RESPONSE TO SUBMISSIONS – SSD 6513 MOD 3 BUILDING R1, BARANGAROO SOUTH

This letter has been prepared by Ethos Urban (formerly JBA) on behalf of Lend Lease Millers Point in relation to the section 96(1A) application (MOD 3) to modify SSD6513 being Building R1, Barangaroo South.

This letter provides a response to the submission made by the City of Sydney, dated 4 October 2017, and information requested by the Department of Planning and Environment (the Department) via email dated 3 October 2017. Each issue is addressed under separate heading below.

Solotel – Barangaroo House
External signage

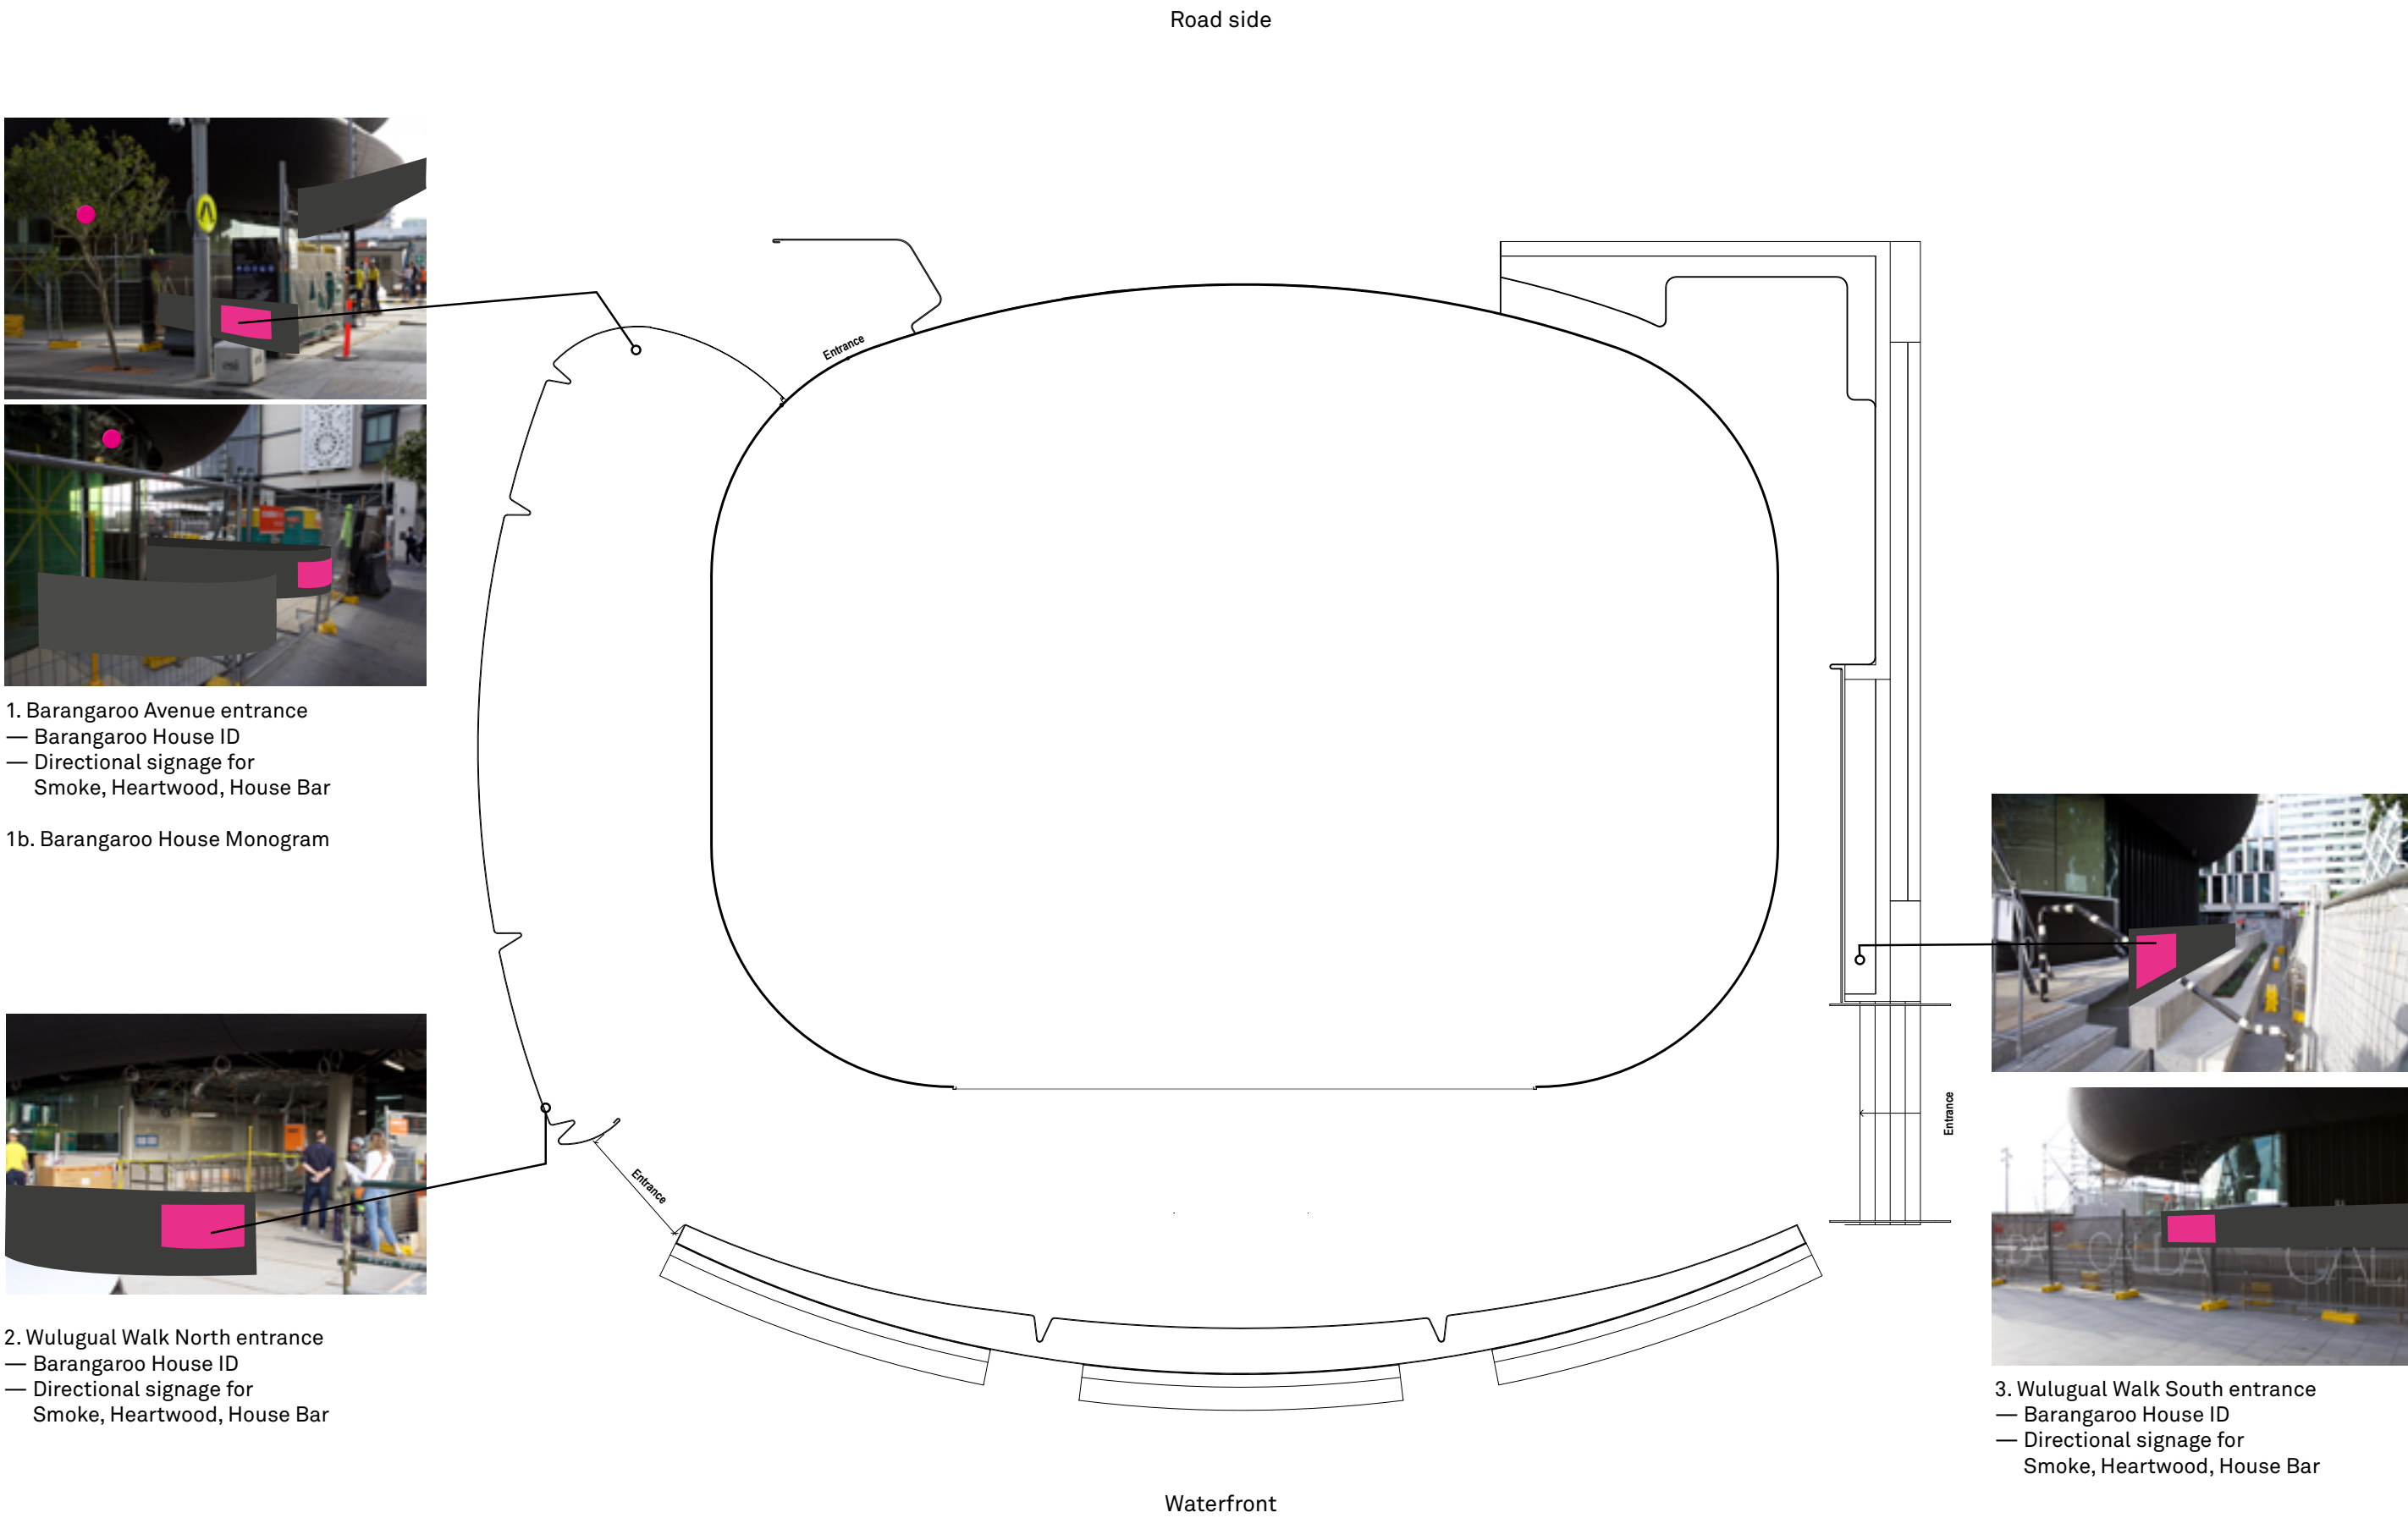
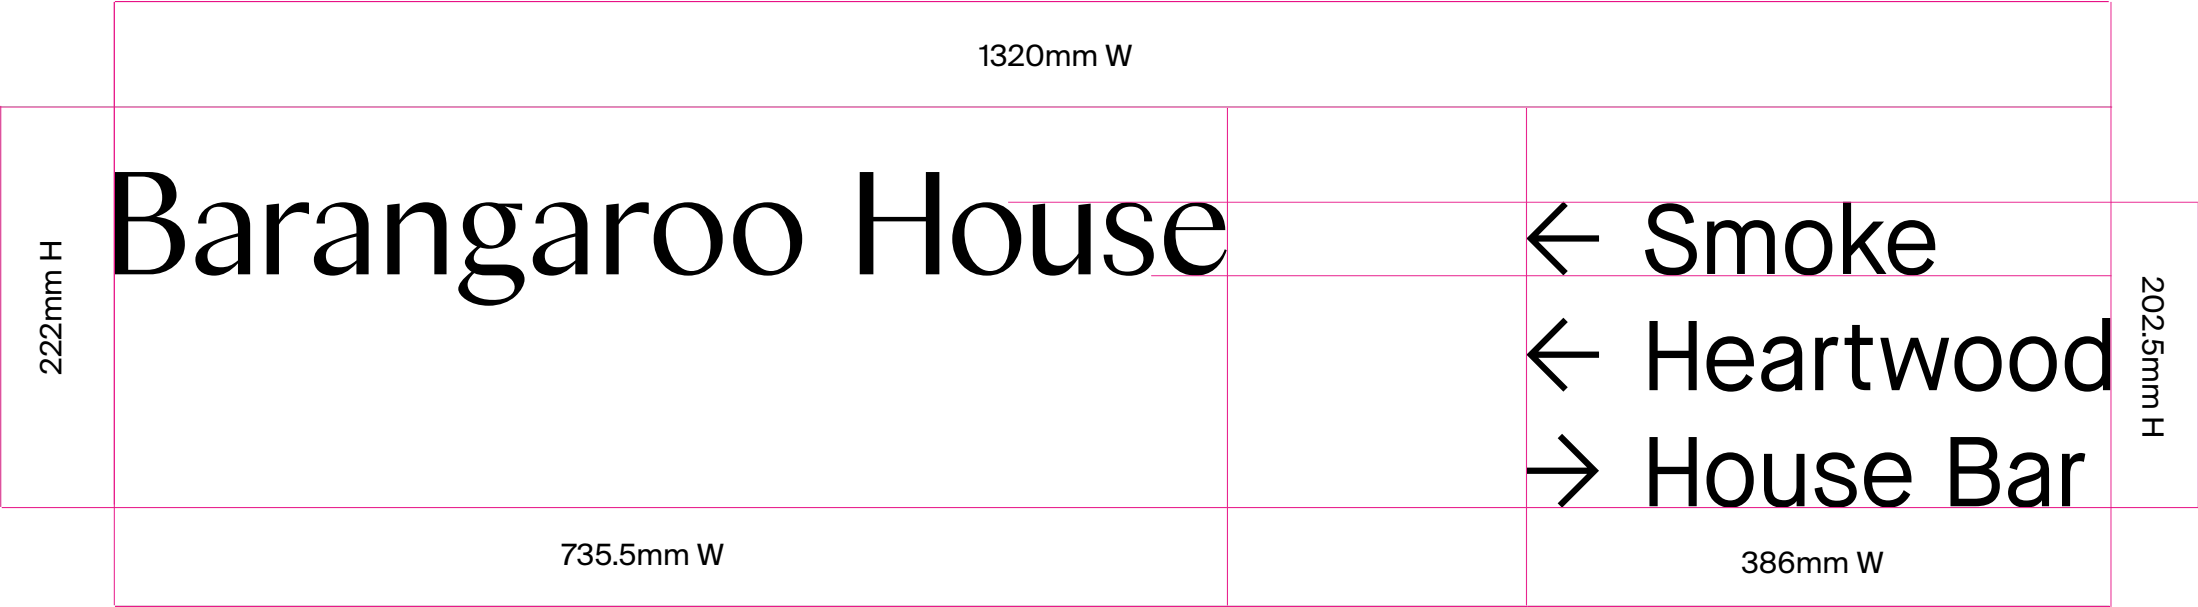
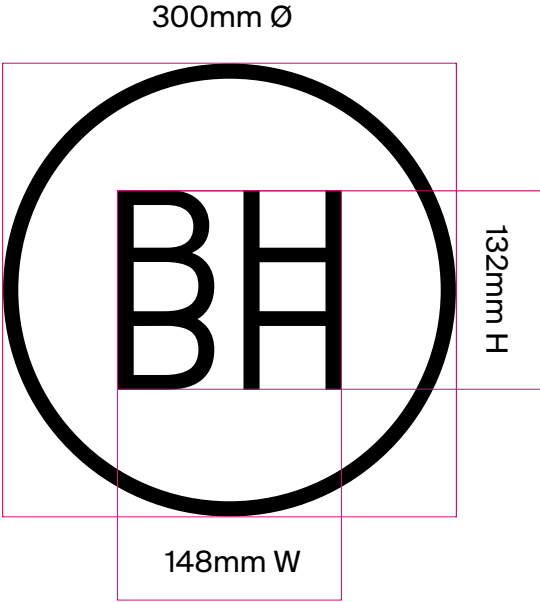
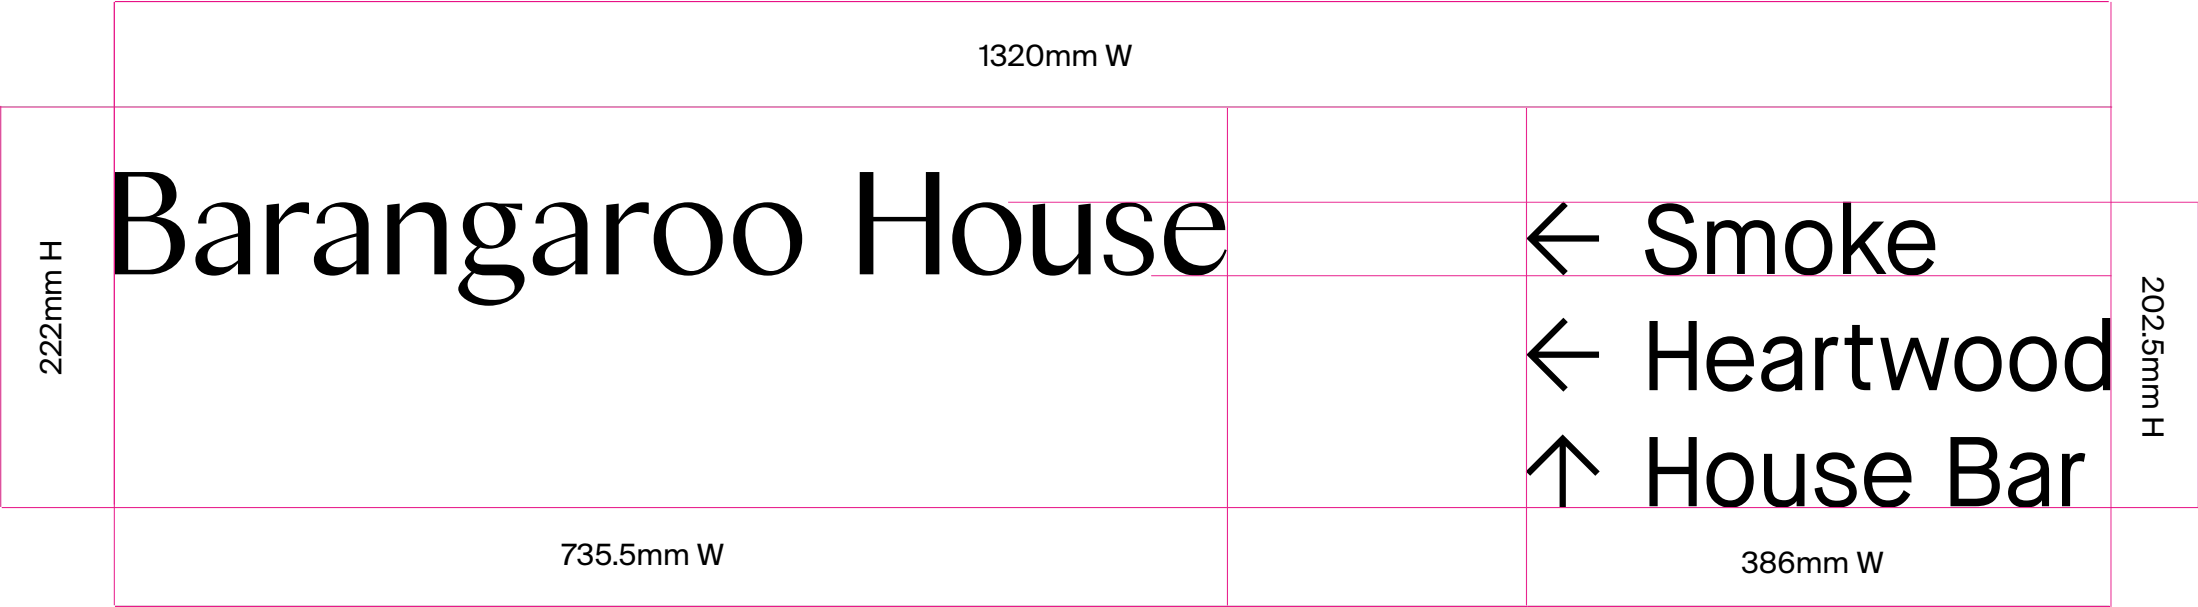
Signage Zones

The proposed modifications include the introduction of four (4) signage zones. The zones will be positioned above entry doors and against the proposed ground floor steel planter boxes surrounding the building. Specifically:

- A signage zone with dimensions of 1200mm x 600mm is proposed over the entry door on the north-east corner of building façade;
- A signage zone with dimensions of 2000mm x 600mm is proposed on the exterior of the steel planter box on the northern façade adjacent to the entry door;
- A signage zone with dimensions of 2000mm x 600mm is proposed on the exterior of the steel planter box on the southern façade; and
- A signage zone with dimensions of 2000mm x 600mm is proposed on the exterior of the steel planter box on the western façade.

The signage within these zones will be for business identification and directional signage for the operation of the venue. A preliminary signage concept is presented at **Attachment B** for information purposes. This sets out proposed metal detailing of venue name and logo and shows that the signage will be flat mounted to existing glazing (above entry door) and flat mounted to the folded metal planter.
